Rezoning Transportation Analysis

Petition Number: 2022-216

Date	Description
05-24-2023	First Review (JP)
11-27-2023	Second Review (TP)
12-19-2023	Third Review (IW)
01-24-2024	Fourth Review (KC)

SHEET TITLE:  
 REZONING PLAN  
 PETITION 2022-216

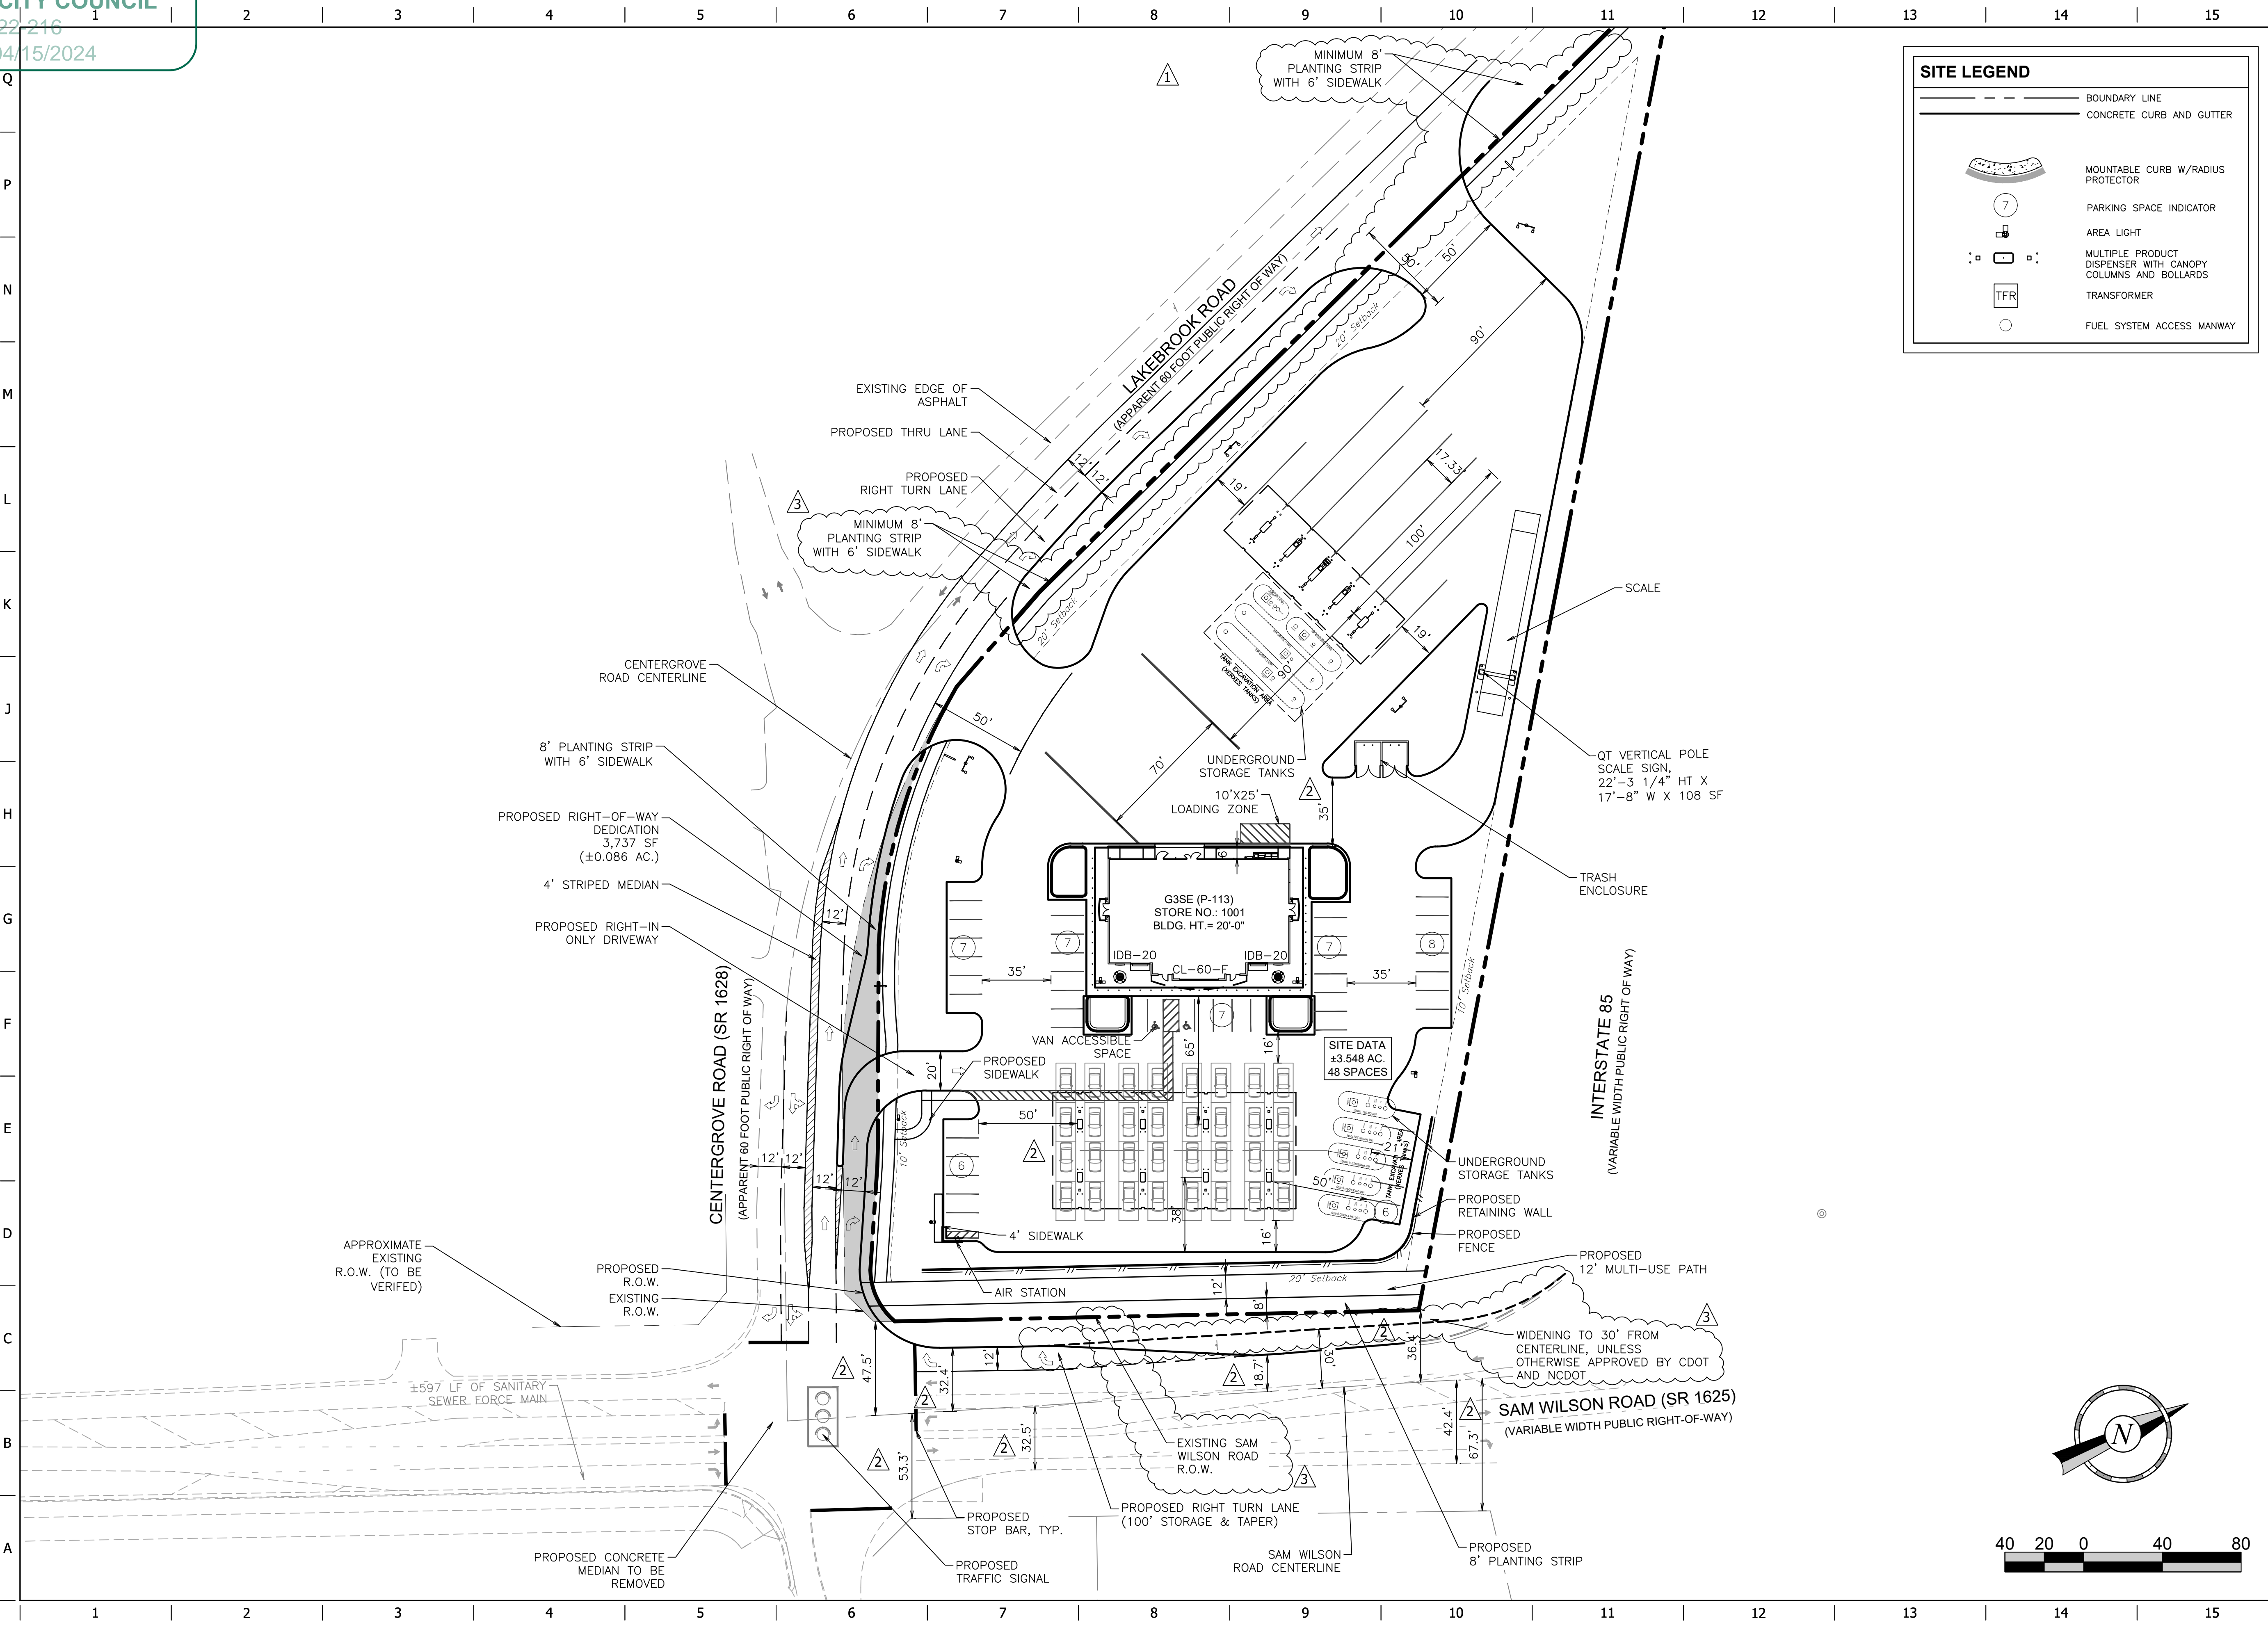
Clarifying comment 11.27.2023: Label and dimension curb and gutter 30 feet from roadway centerline on Sam Wilson.

Clarifying comment 11.27.2023: Label and dimension right of way from roadway centerline on Sam Wilson.

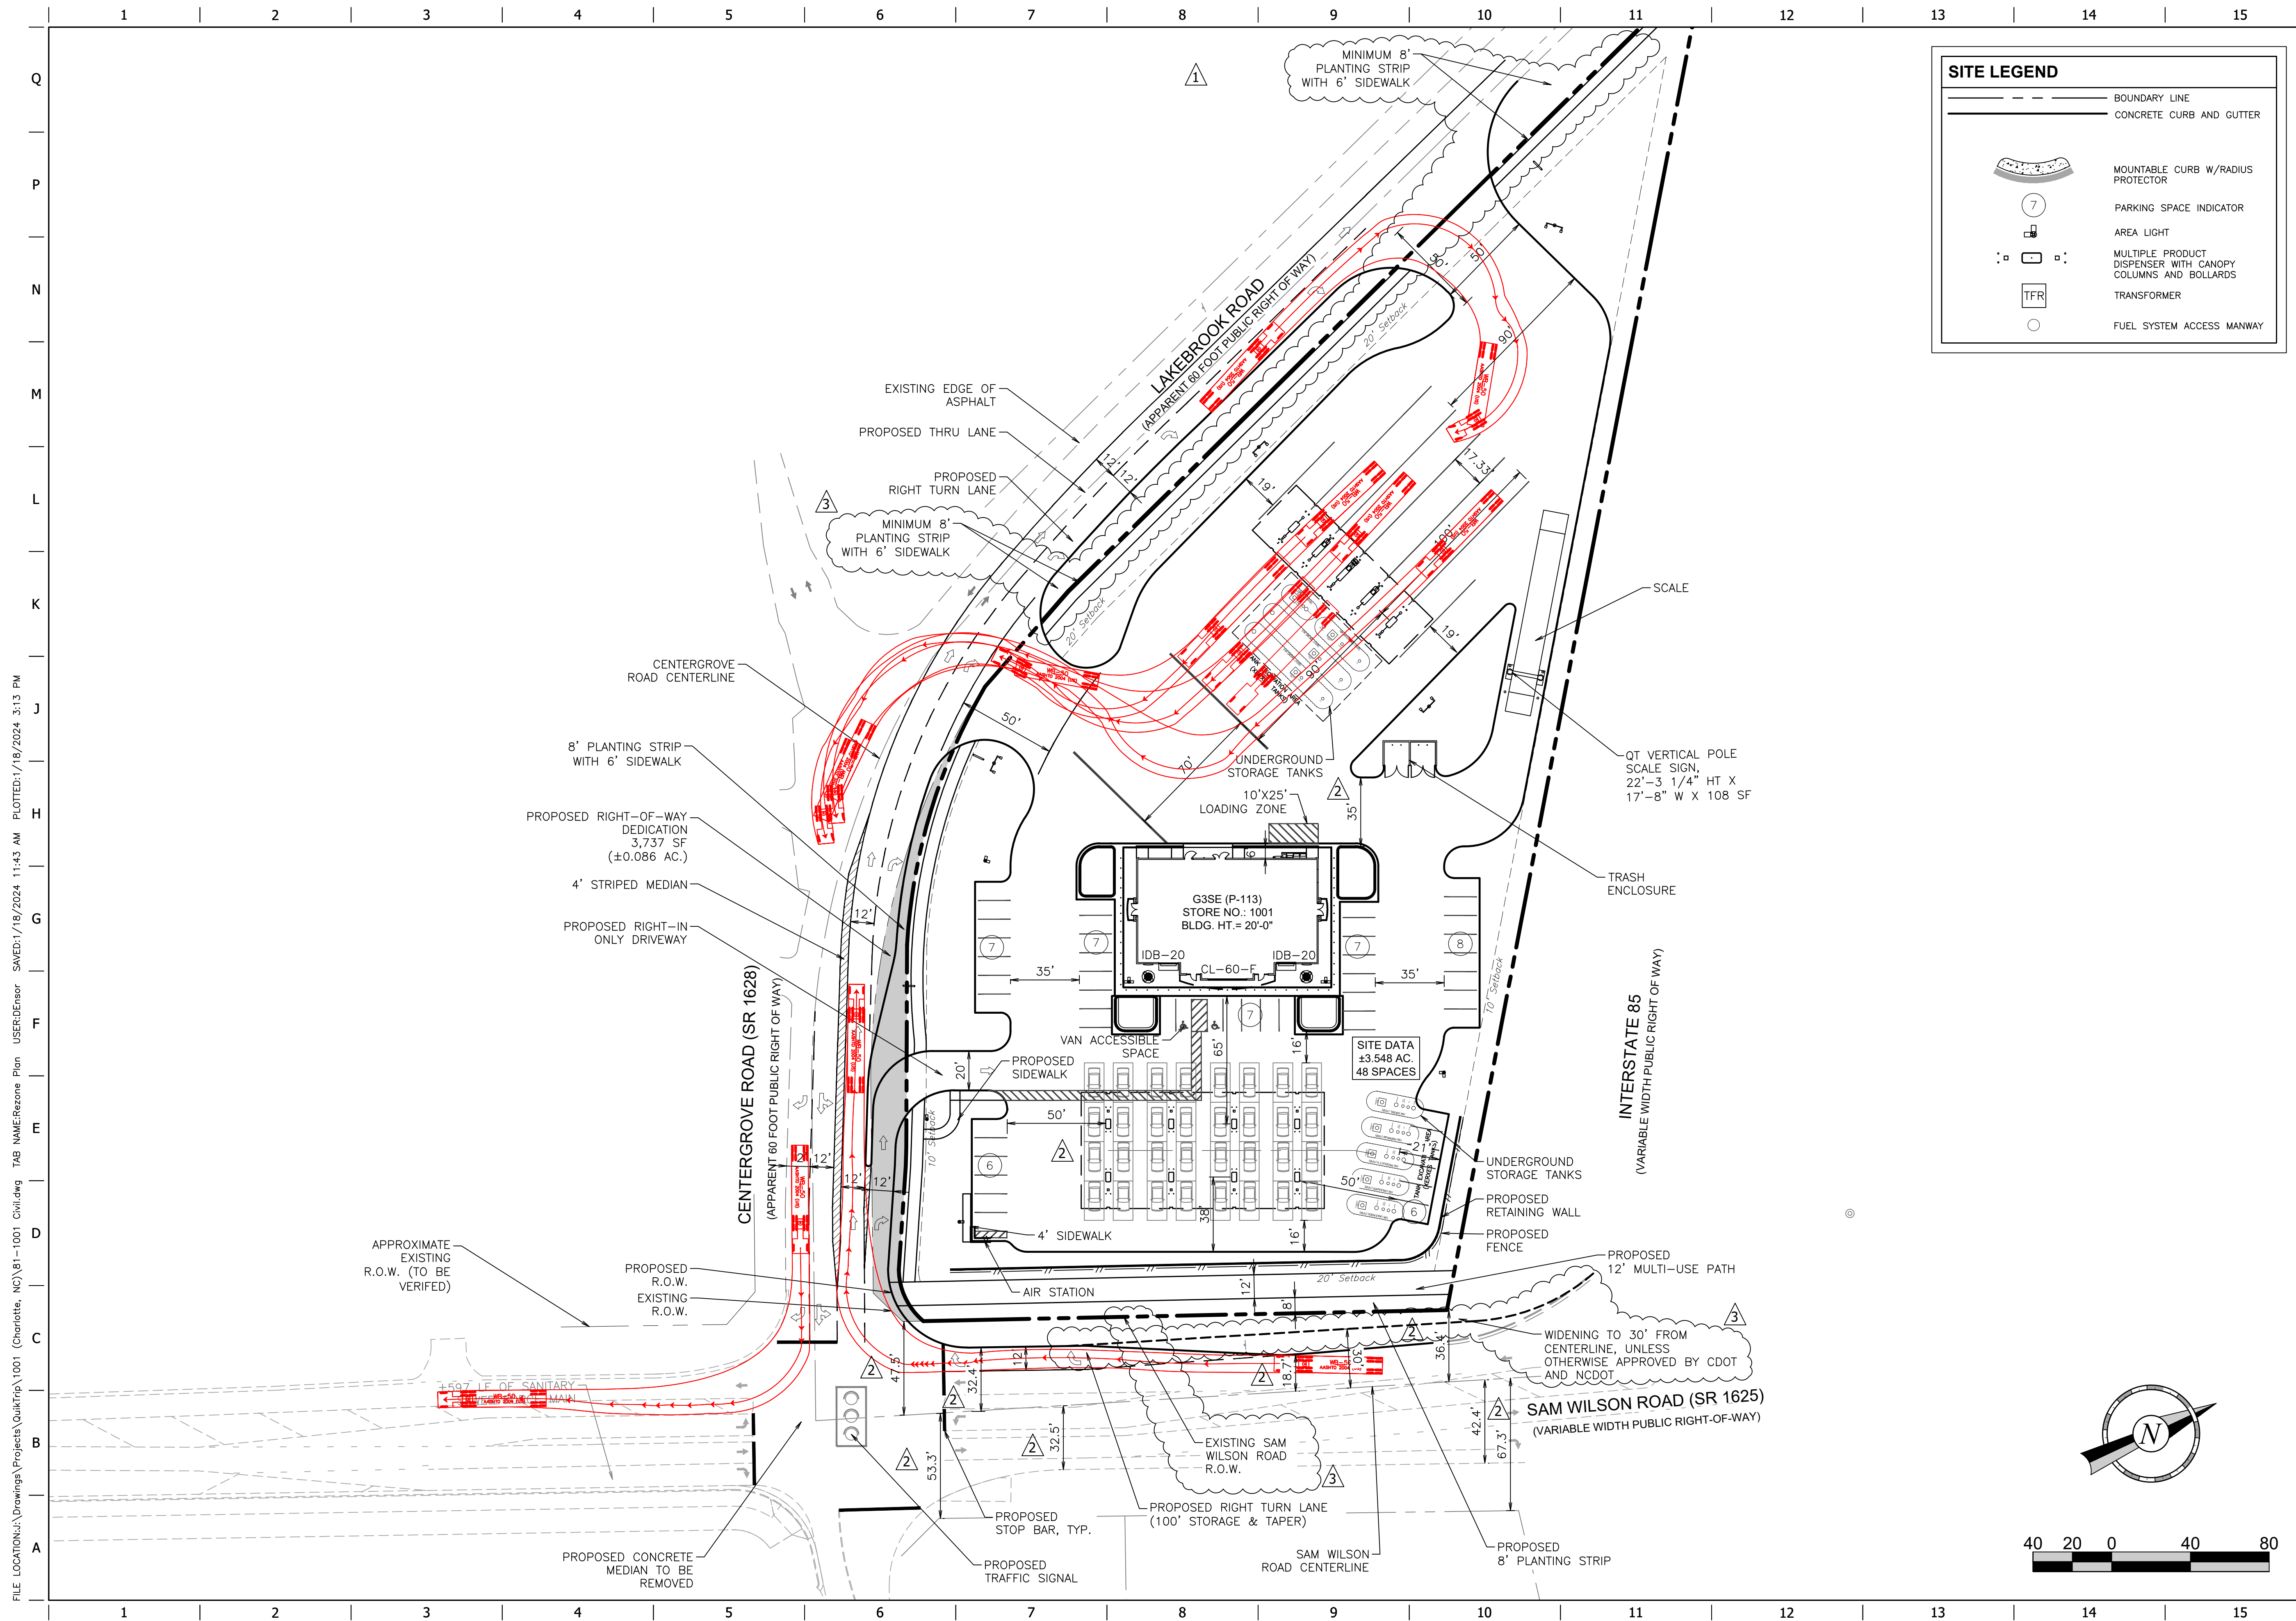
- New comment 01.24.2024:** Conflict with revised site plan and conditional notes, site plan shows 30' and conditional note states 35' please address.

- New Comment 12-20-2023:** Revise site plan to clearly show and label the location of existing right of way and proposed right of way.

Clarifying comment 01.24.2024: Label and clearly dimension the existing right of way and the proposed right of way.
